**From:** Neil Whitton  
**Sent:** 04 January 2022 11:16  
**To:** Gemma Magnuson  
**Cc:** DC Support  
**Subject:** 21/04156/F - Bicester Hotel Golf And Country Club, Akeman Street, Chesterton, Bicester, Oxfordshire, OX26 1TE

Environmental Protection has the following response to this application as presented:

Proposed plans and Elevations

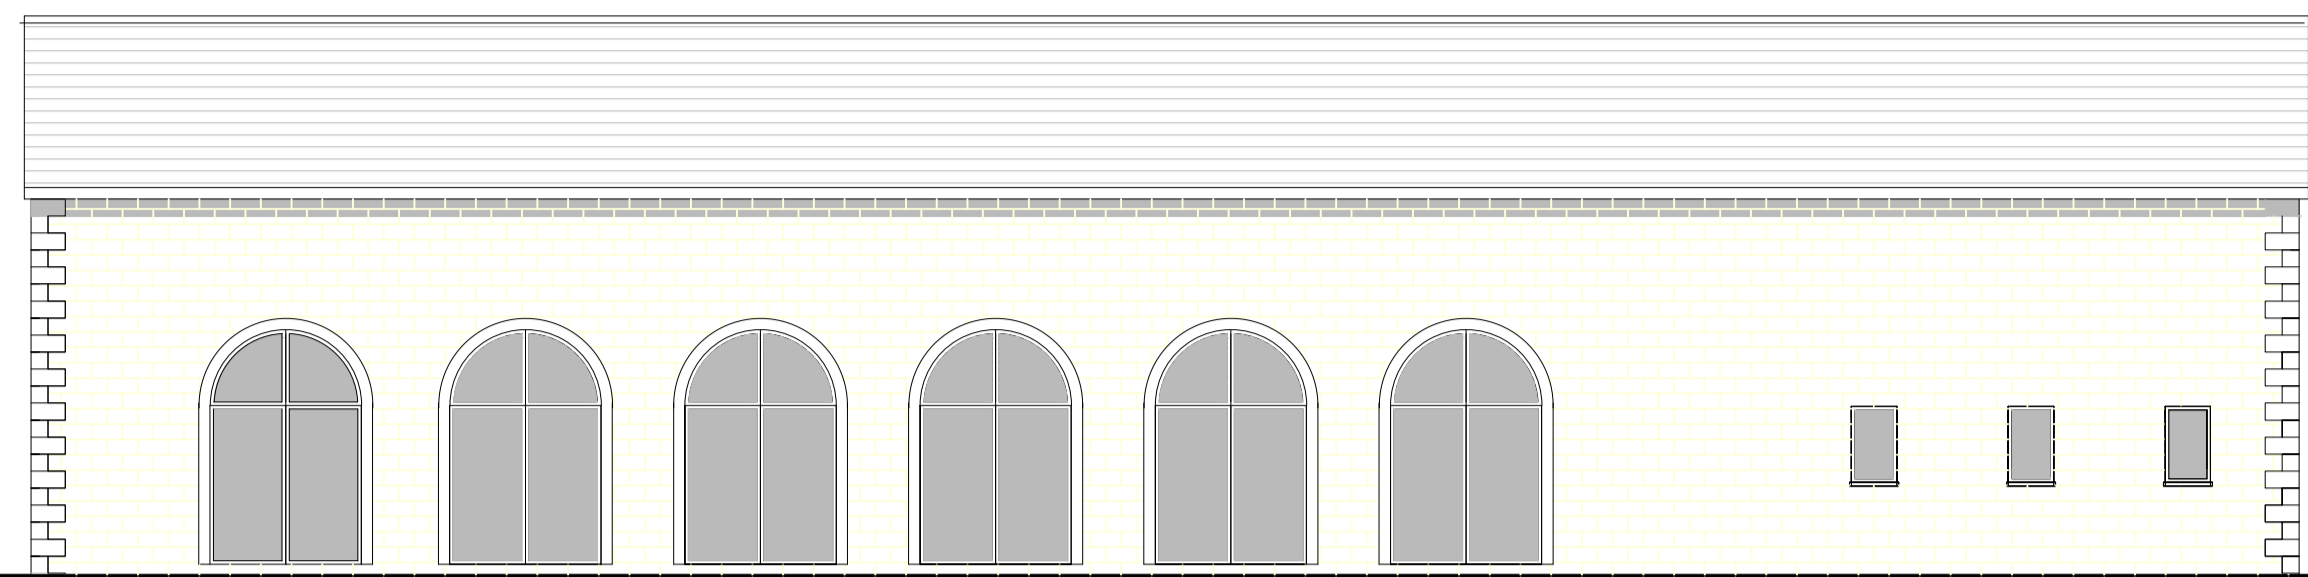
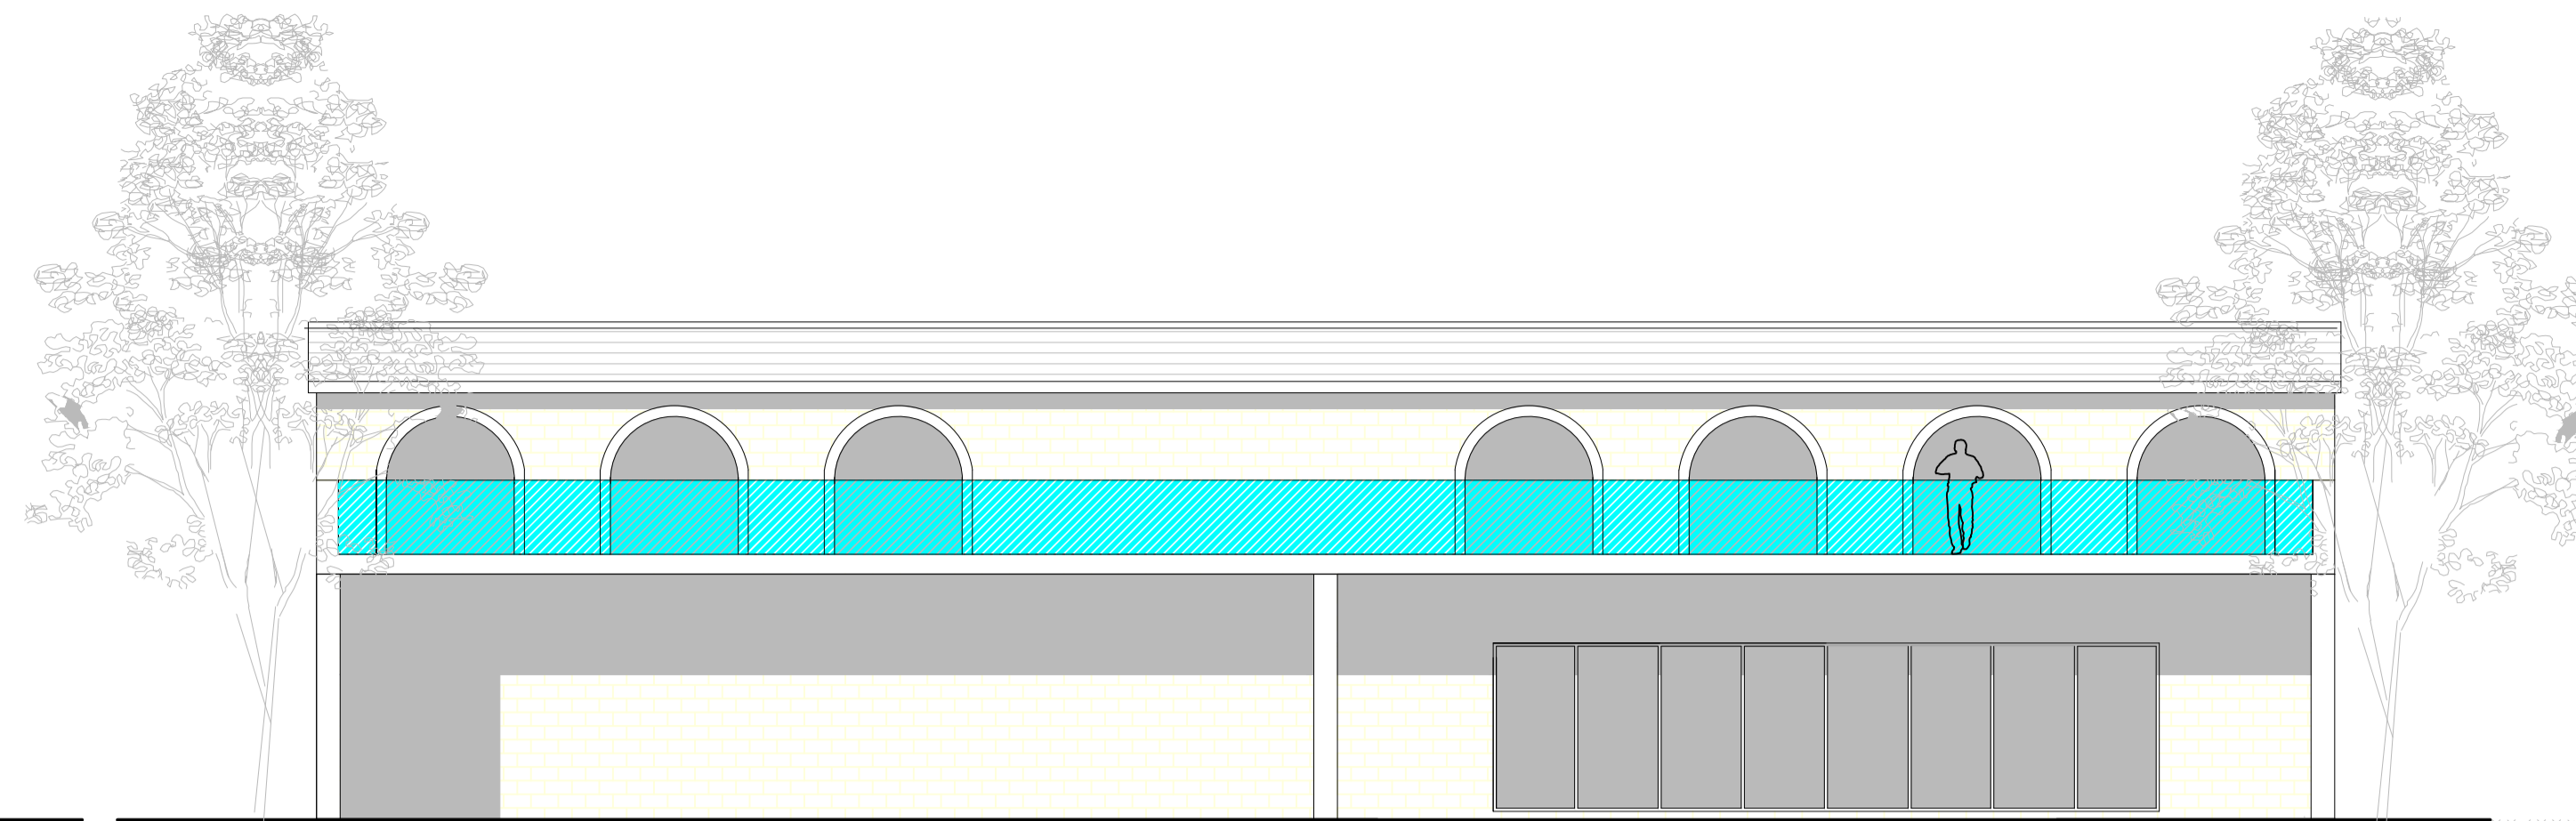
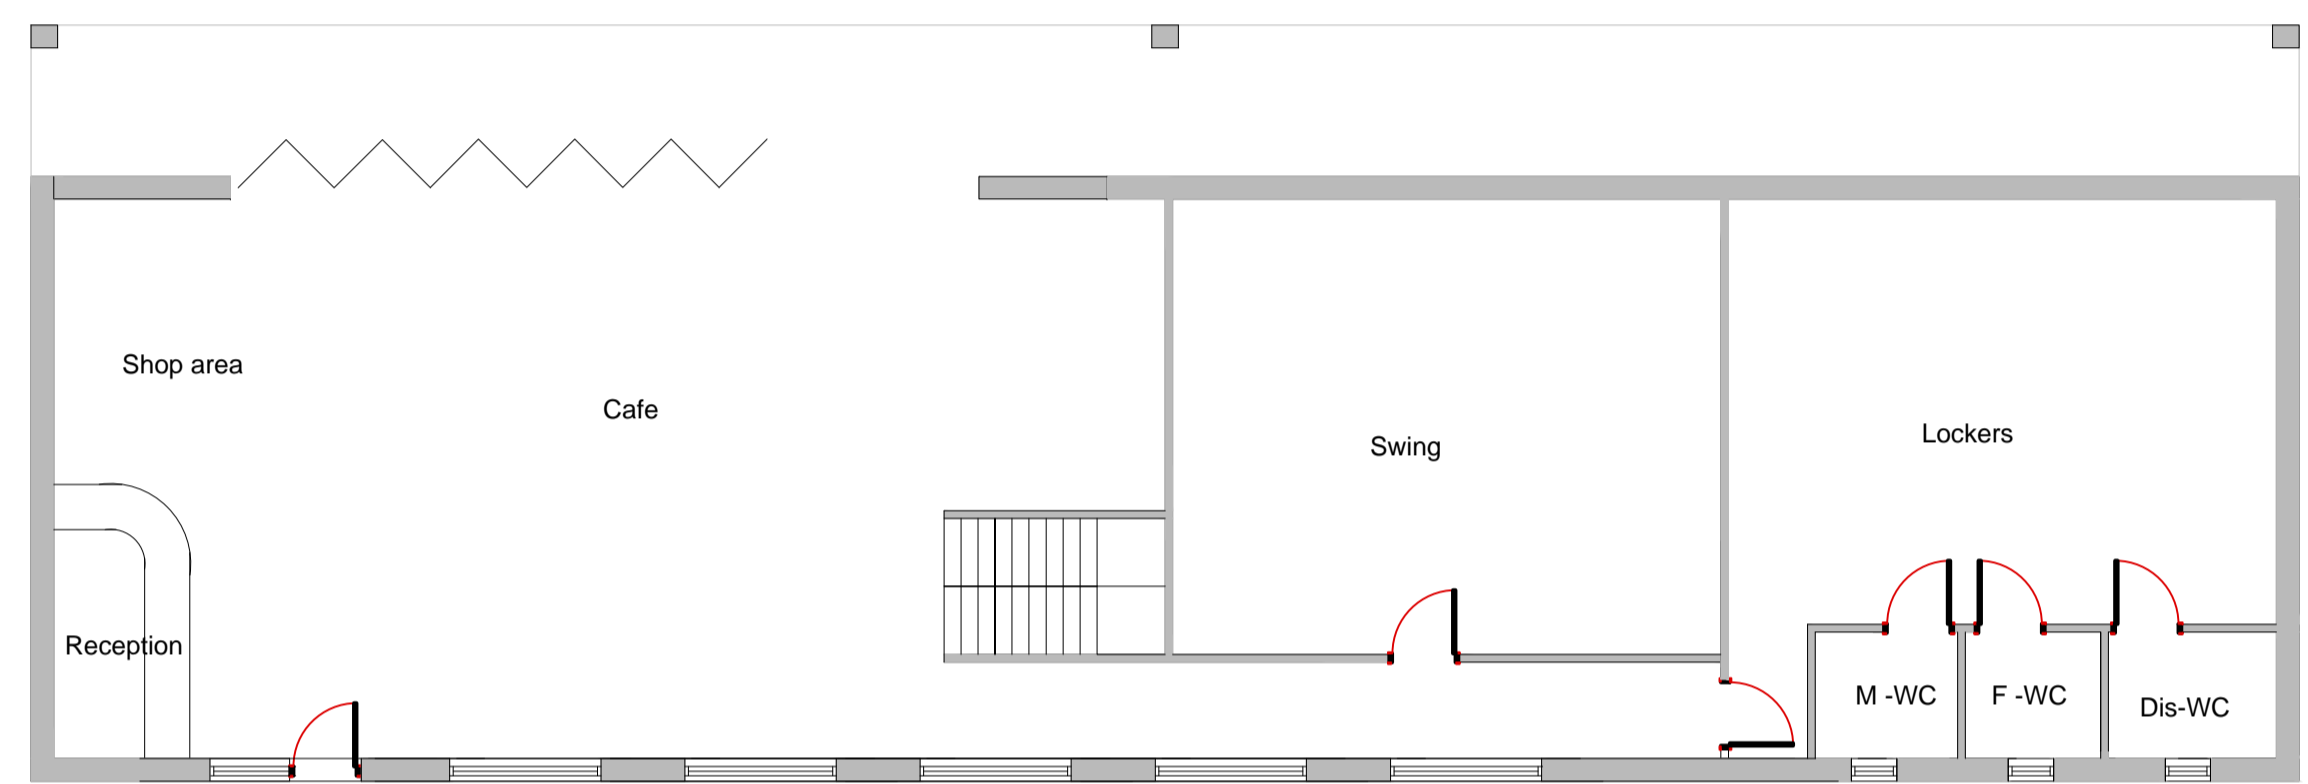
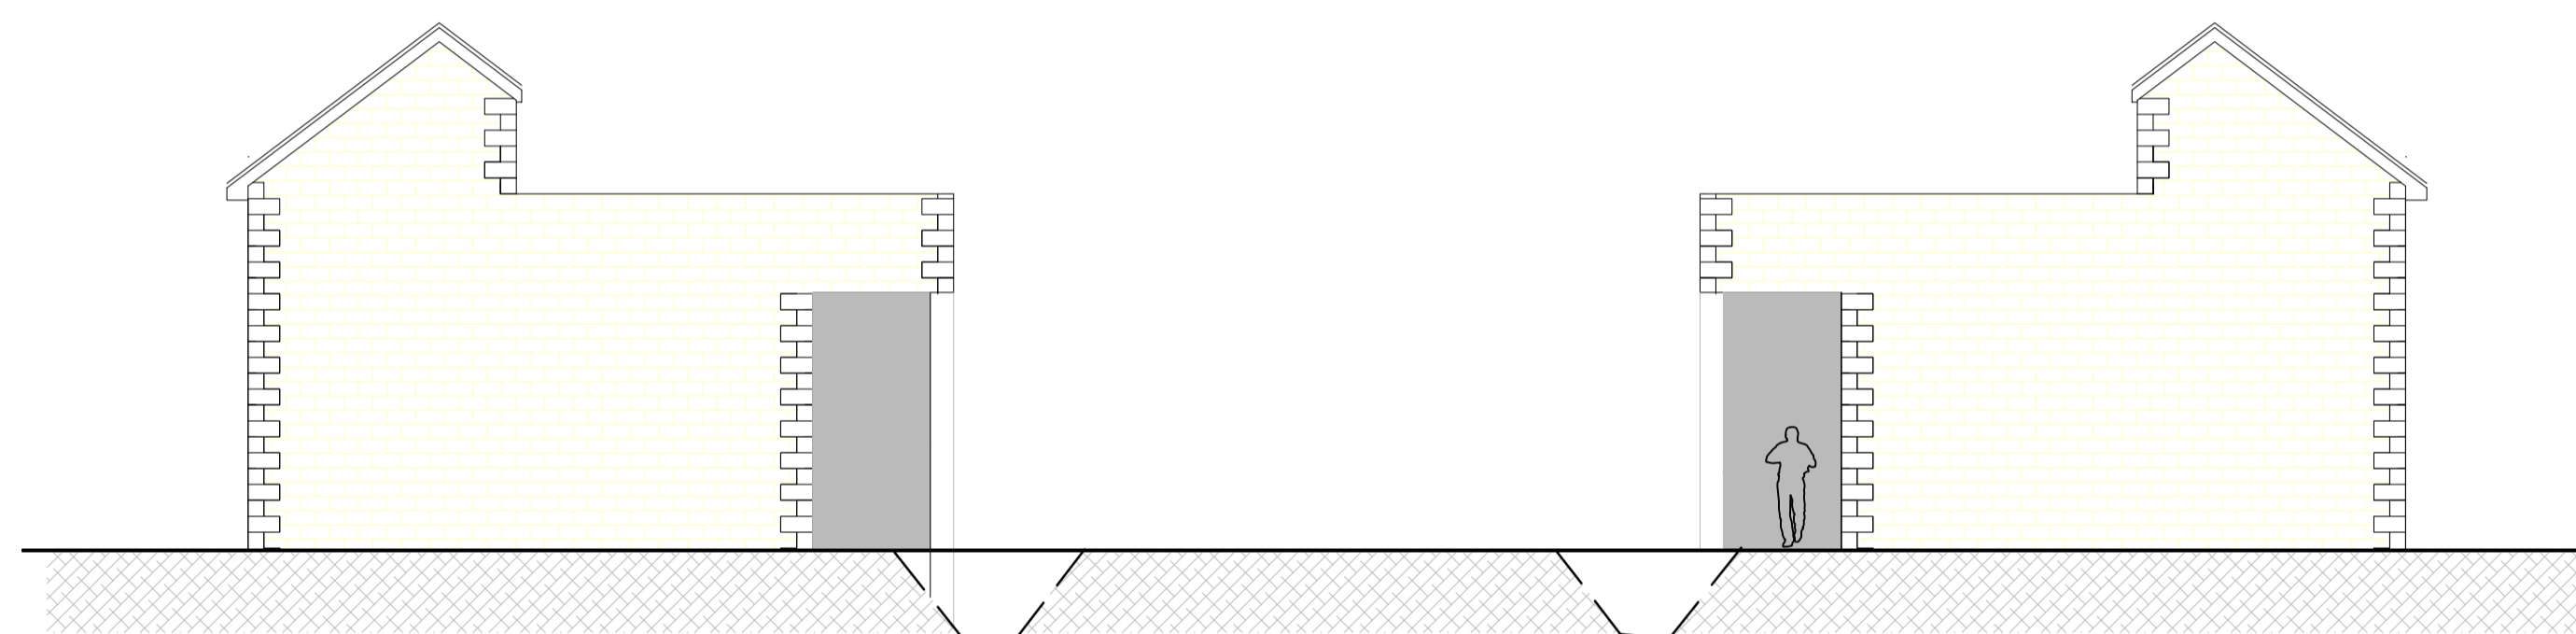
There is no mention of any extraction system to the proposed café. Should one be required we would like to see details of this and it be agreed with the LPA prior to installation.
